**Submission**

WestConnex M4-M5 Link MOD2  
Application number SSI 7485.

**Change the overpass to a tunnel**

Figure 4-4 Elevation: Indicative view of The Crescent overpass

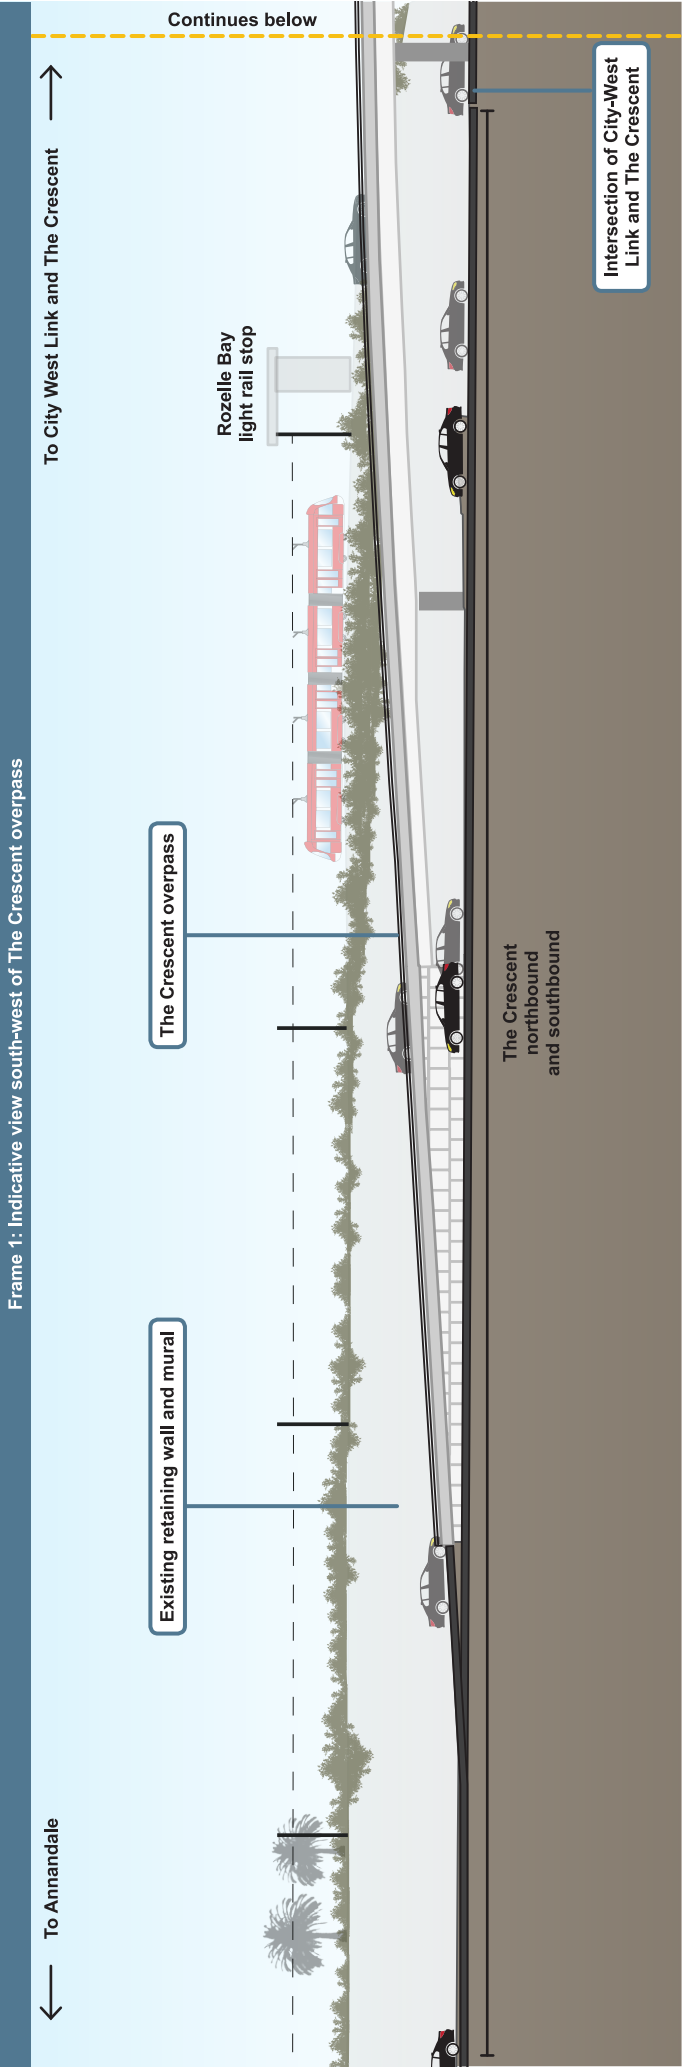
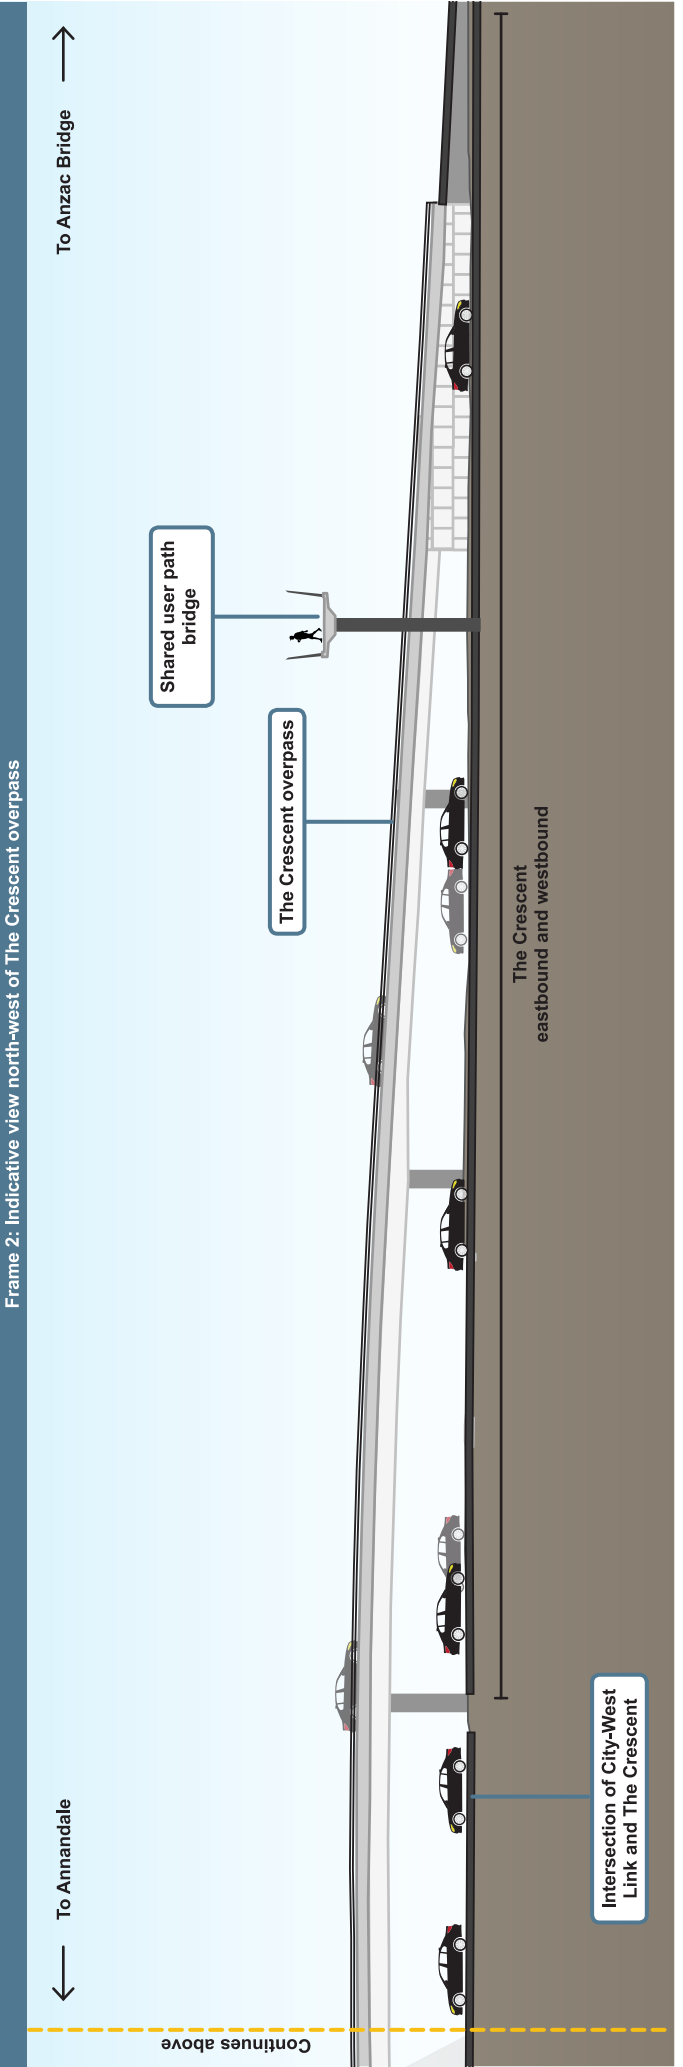
I oppose the proposal to build an overpass at The Crescent in Annandale. The plan for an overpass should be replaced by a tunnel.

The overpass is a truly horrendous outcome and demonstrates the failure to learn from bayside precedents such Darling Harbor and Circular Quay which, while at a greater scale, are nonetheless both well recognized as highly compromised by elevated transport infrastructure.

- The proposed overpass is visually offensive. It's bulk and scale is not in keeping with the transition from parkland and fine grained neighborhoods, (The scale of the roads below don't magically justify increased infrastructural context, quite the opposite)
- It blocks and compromises views, lessening the enjoyment, quality and value of the area
- It breaks what was a fairly sensible, direct (and approved) East West pedestrian link adjacent the Rozelle Light Rail. The approved East West link was a far superior urban outcome than the spaghetti proposed in the modification.

An underpass road instead of an overpass, provides the best visual and urban outcomes and should allow the retention of the green bridge in a location to best connect the parklands and residential neighborhoods together.

Figure 4-5 The Crescent/Johnston Street/Chapman Road intersection

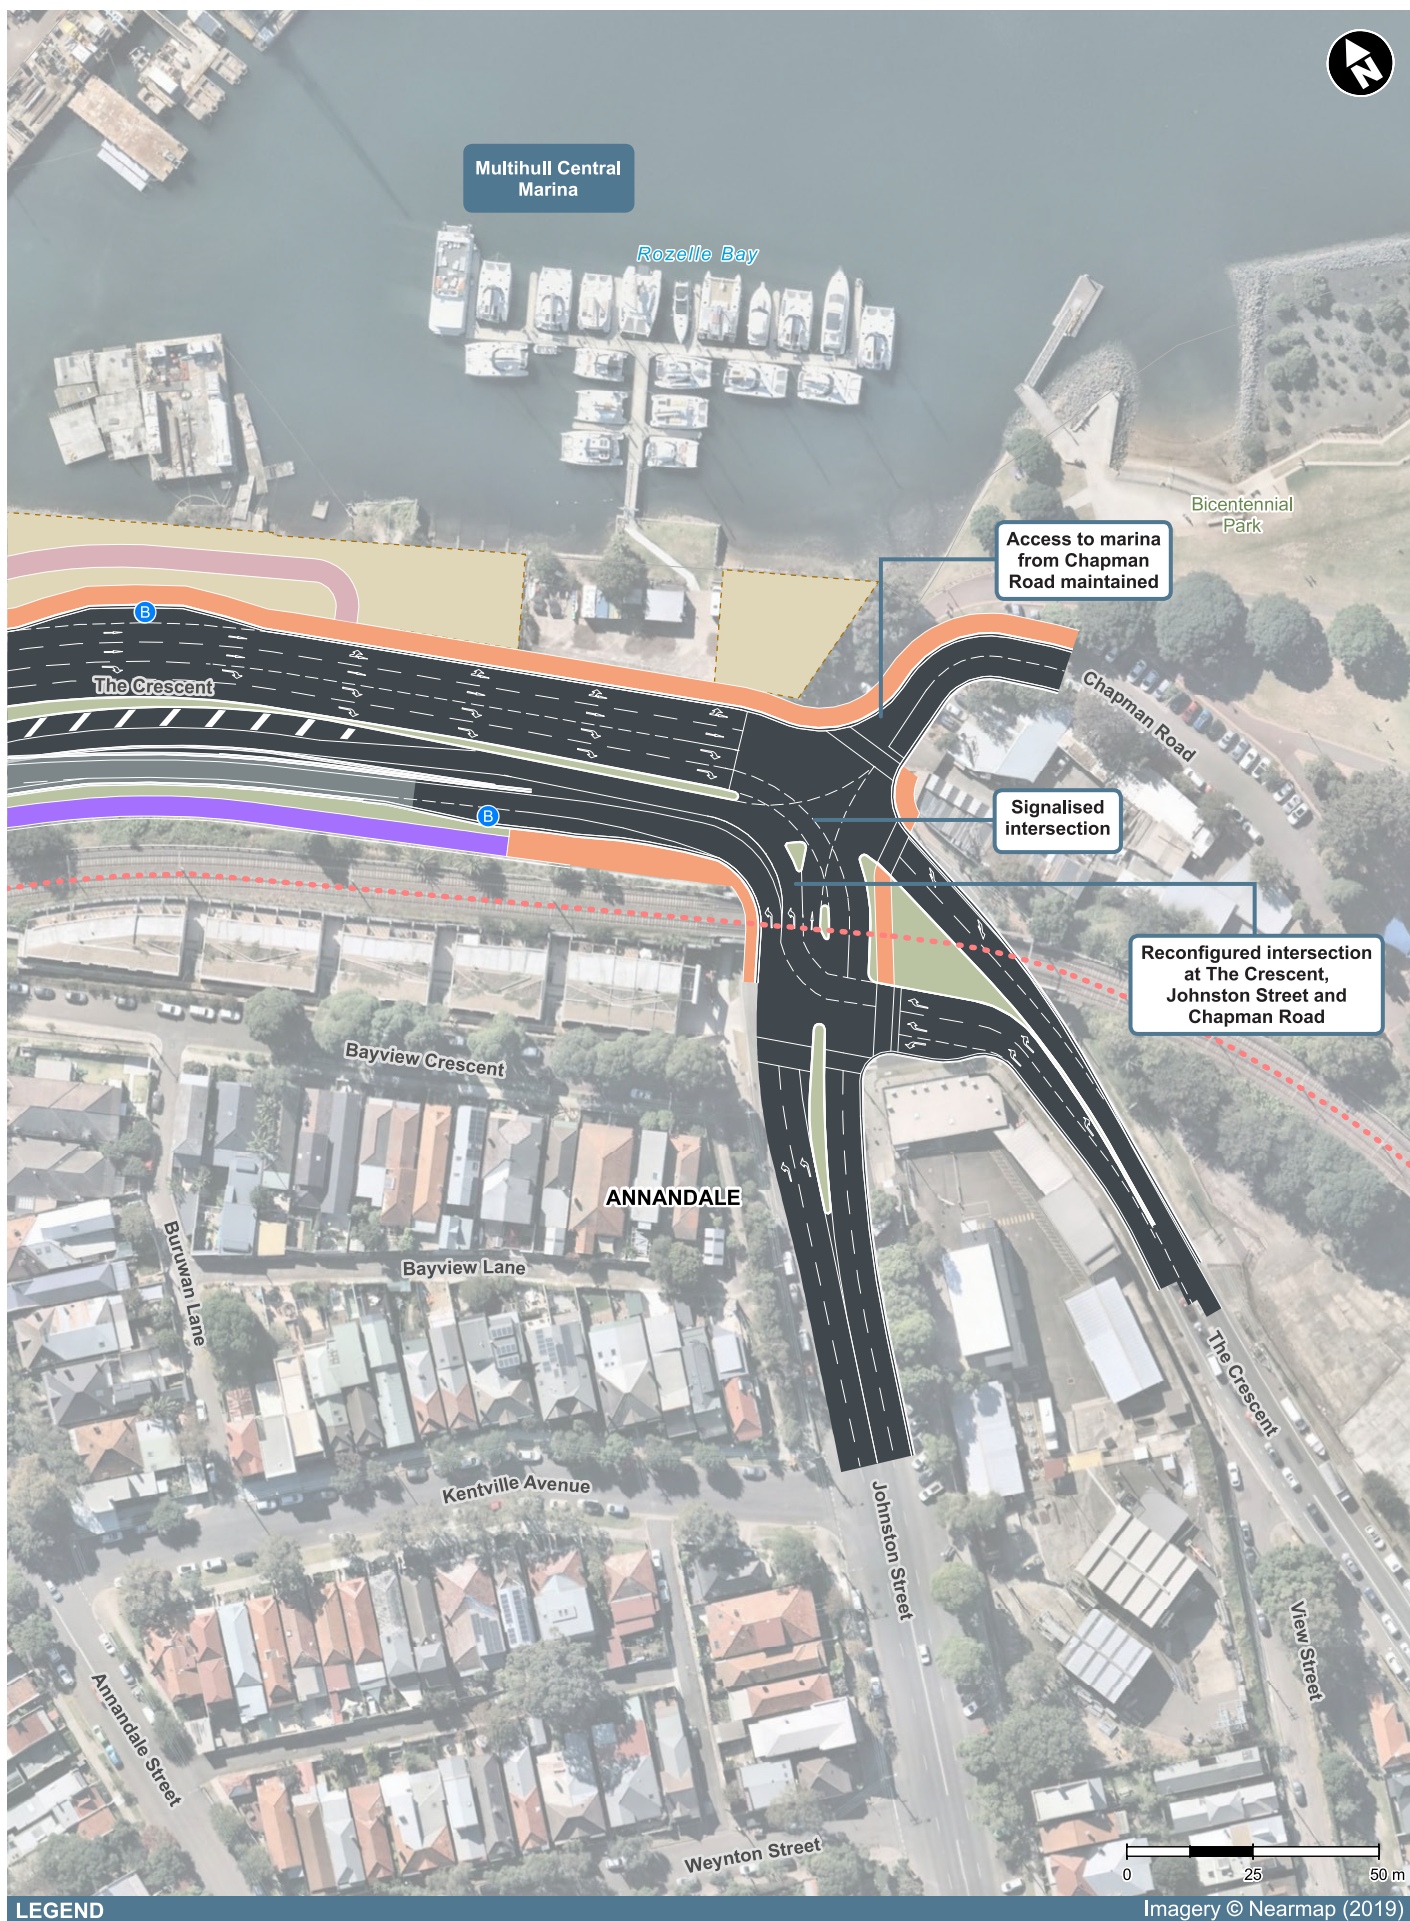
The proposed modification is hideously convoluted and a huge step backwards. It beggars belief that this would even be proposed.

- Maintain the existing east west on grade crossing on the North West corner of Johnston St and the Crescent or design a better solution.

Figure 4-6 Elevation: Indicative view of Rozelle Rail Yards Pedestrian and Cycling Green Link

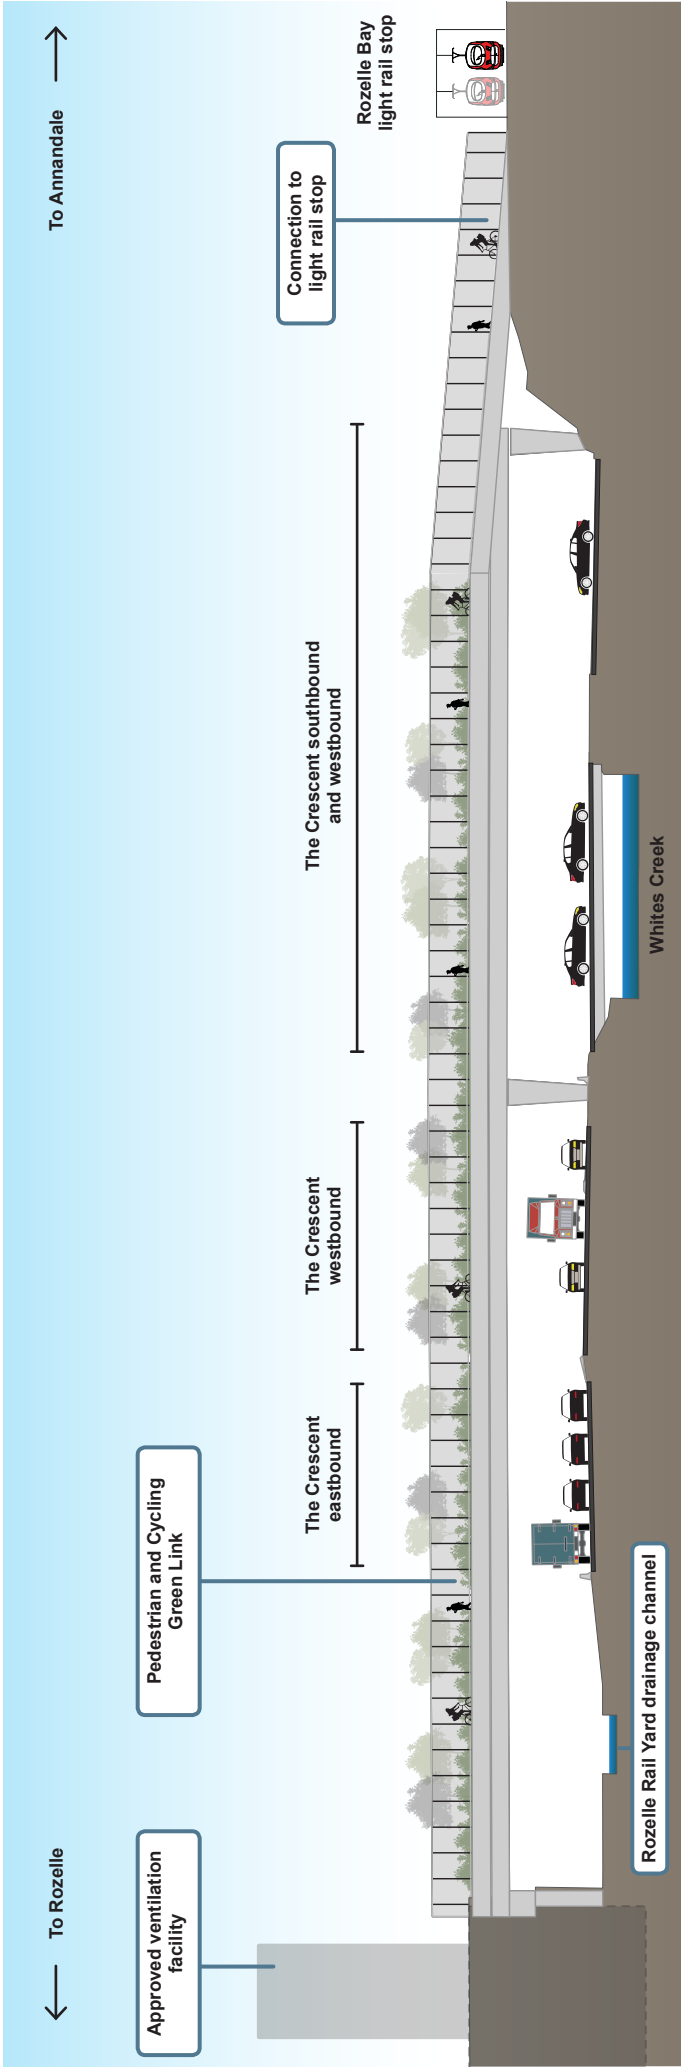
- It distorts, dislocates and blockades the Green link and puts it on the wrong side of the Crescent. The approved green link has the potential to be an iconic success, a triumph of good design, a celebration of the public domain and a fantastic publicity piece worthy of an international city.

Figure 4-7 Elevation: Indicative view of the shared user path bridge

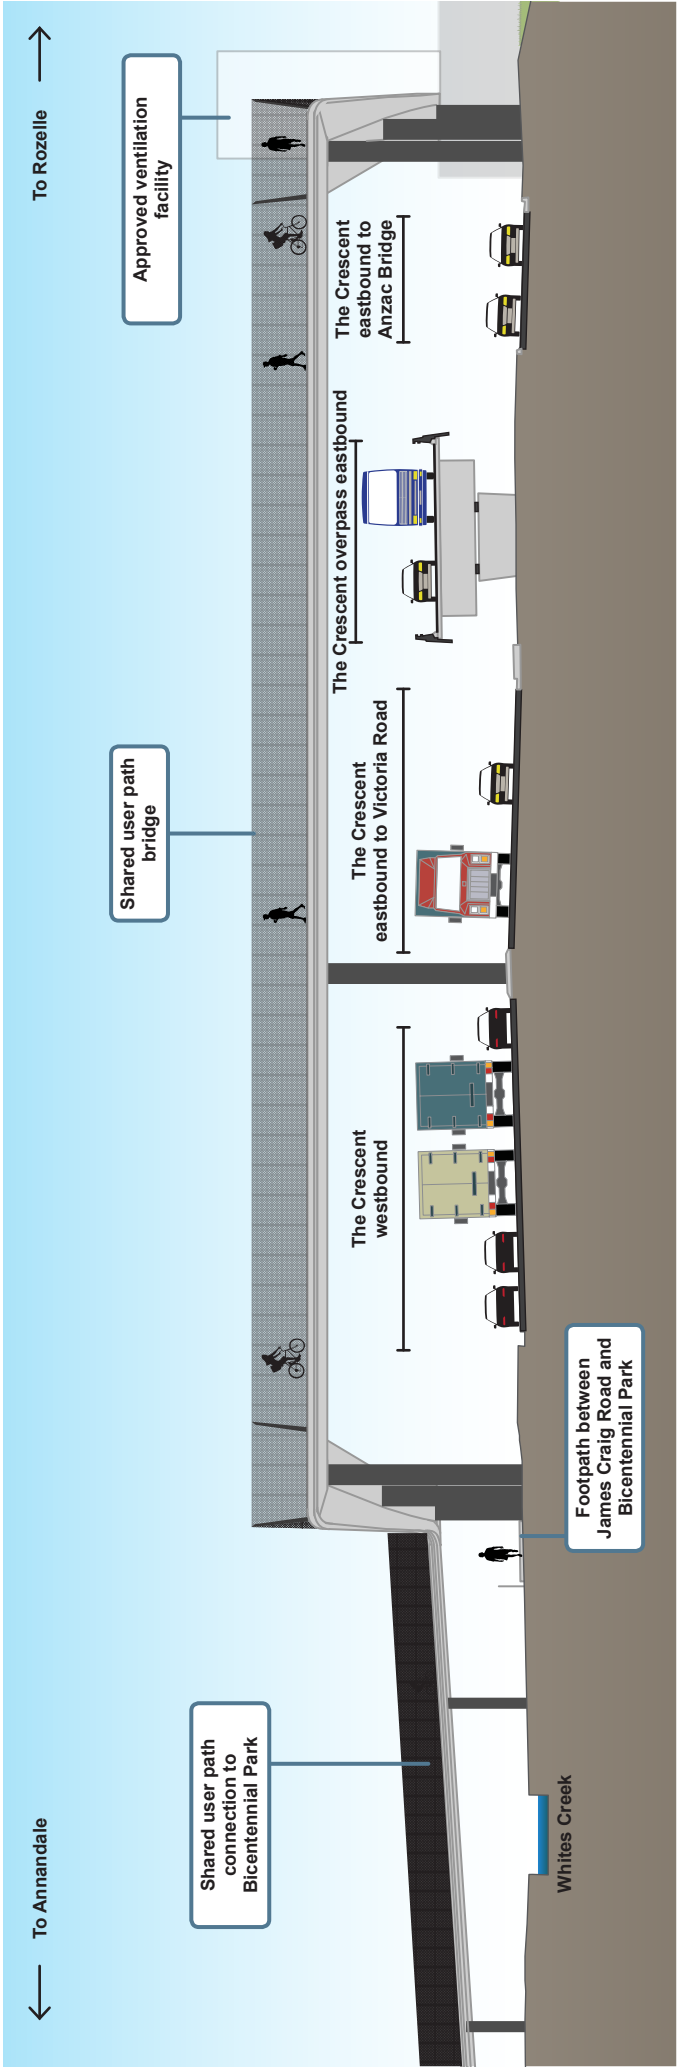
- The double stacking of the proposed circuitous “Shared user path” over the proposed vehicle overpass would be laughable if it wasn’t so embarrassingly tragic and represents a complete reversal of correct priorities and loss of project control.
